A303 Sparkford – Ilchester dualling project

From Sarah Bucks, Chair, South Somerset Bridleways Association

7th. March 2019

Our comments for DEADLINE 4

Appendix 2 POTENTIAL LEGACY ISSUES IF ONLY PARTIAL REVOCATION OF 1996 SRO

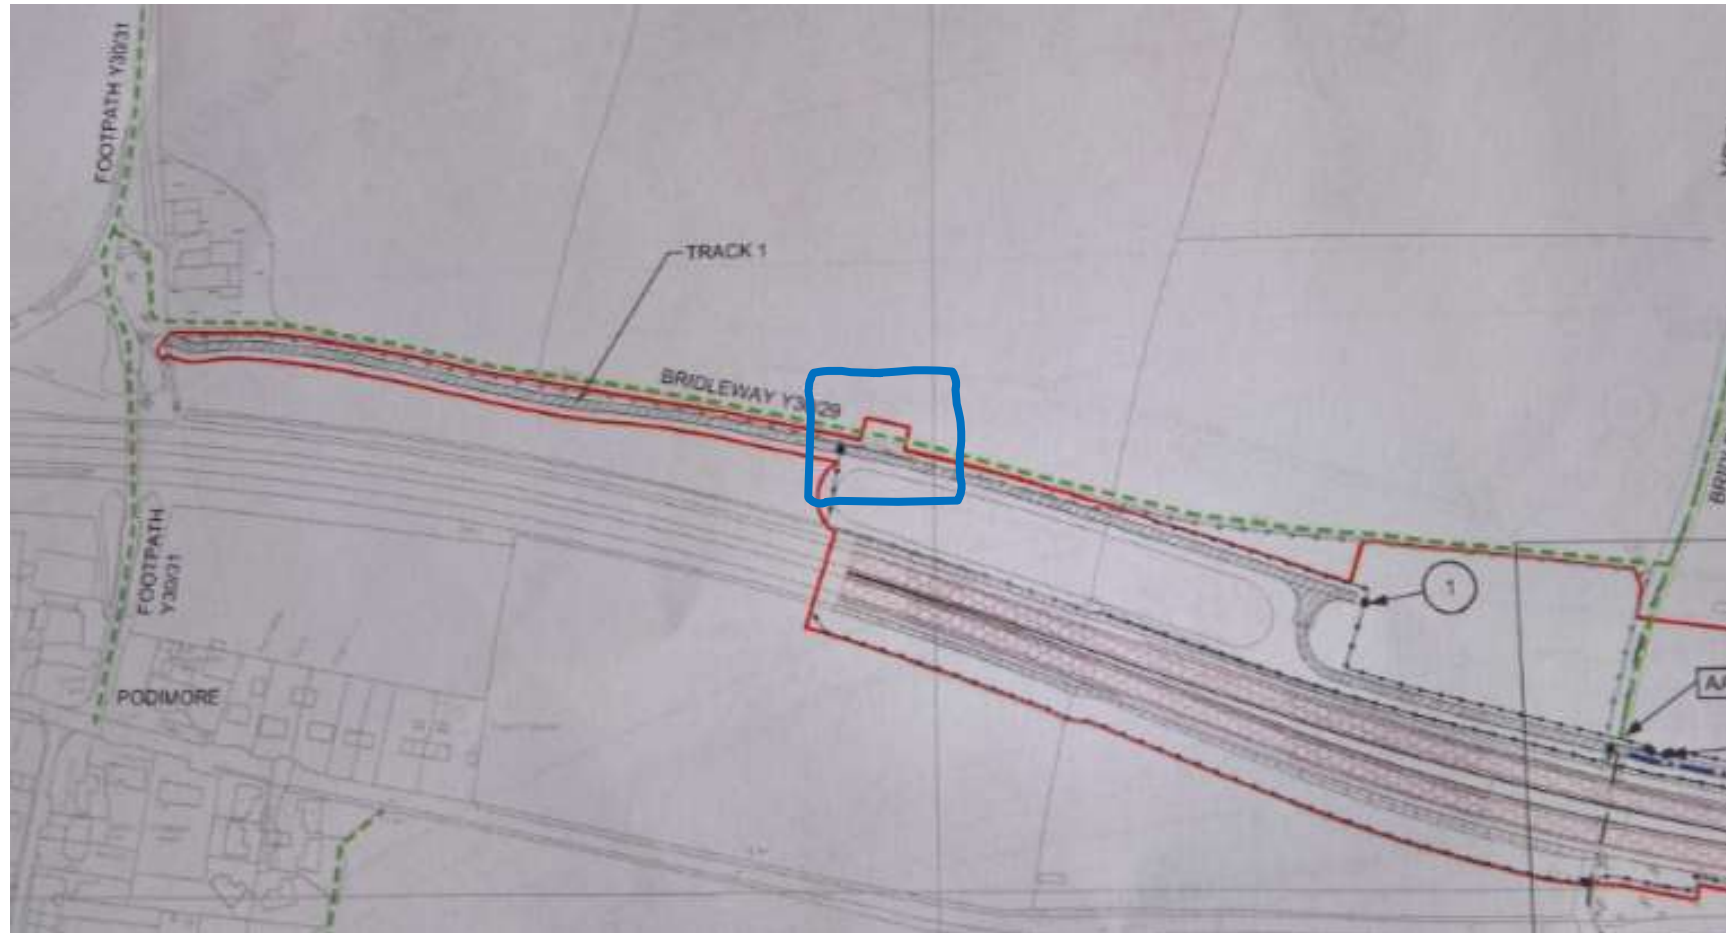
6. Bridleway Y 30/29 in Podimore

This bridleway is shown on the HE scheme plans as a definitive bridleway. This was awarded in the 1996 Side Roads Orders. South Somerset Bridleways Association has believed it to be a bridleway and have asked the surveying authority on very many occasions over the years to record it on the definitive maps and statement. We were never informed that it was not a legal bridleway, and have thus assumed that it was a shortage of resources that was preventing the surveying authority from adding it to the definitive map. Had we been informed that it was not going to be recorded, we would have submitted a LEMO application (Legal Event Modification Order application) citing the side roads orders as the legal event.

As the situation is now in the spotlight, we make the following suggestion, which should satisfy the landowner on the northern side of the hedge, where the line of the bridleway was created.

We understand that the land on the south side of the hedge is now in the ownership of HE and will be used as a construction track and to create drainage ponds in the eastern end of this long field alongside the existing A303 eastbound carriageway.

This bridleway was the link between Podimore and Eastmead Lane. The last few yards at the southern end of Eastmead land, between the existing 303 and the old A303 was legally stopped up when the existing bypass was constructed in 1996. We believe that the bridleway was created in order to connect Eastmead Lane with Podimore. The road over Podimore bridge was always assumed to carry public motorised vehicle rights, and has a dead end sign and a 30 mph limit sign, which indicates this to road users.

We were disappointed to hear at the hearing on Friday 1st. March 2019 that HE intend to revoke the side roads order which created this bridleway without consultation or making alternative provisions or mitigation. In doing so, this is contrary to all HE policies on connectivity and making provision for all road users including equestrians and cyclists. The connection between Eastmead Lane and Podimore depends on this bridleway.
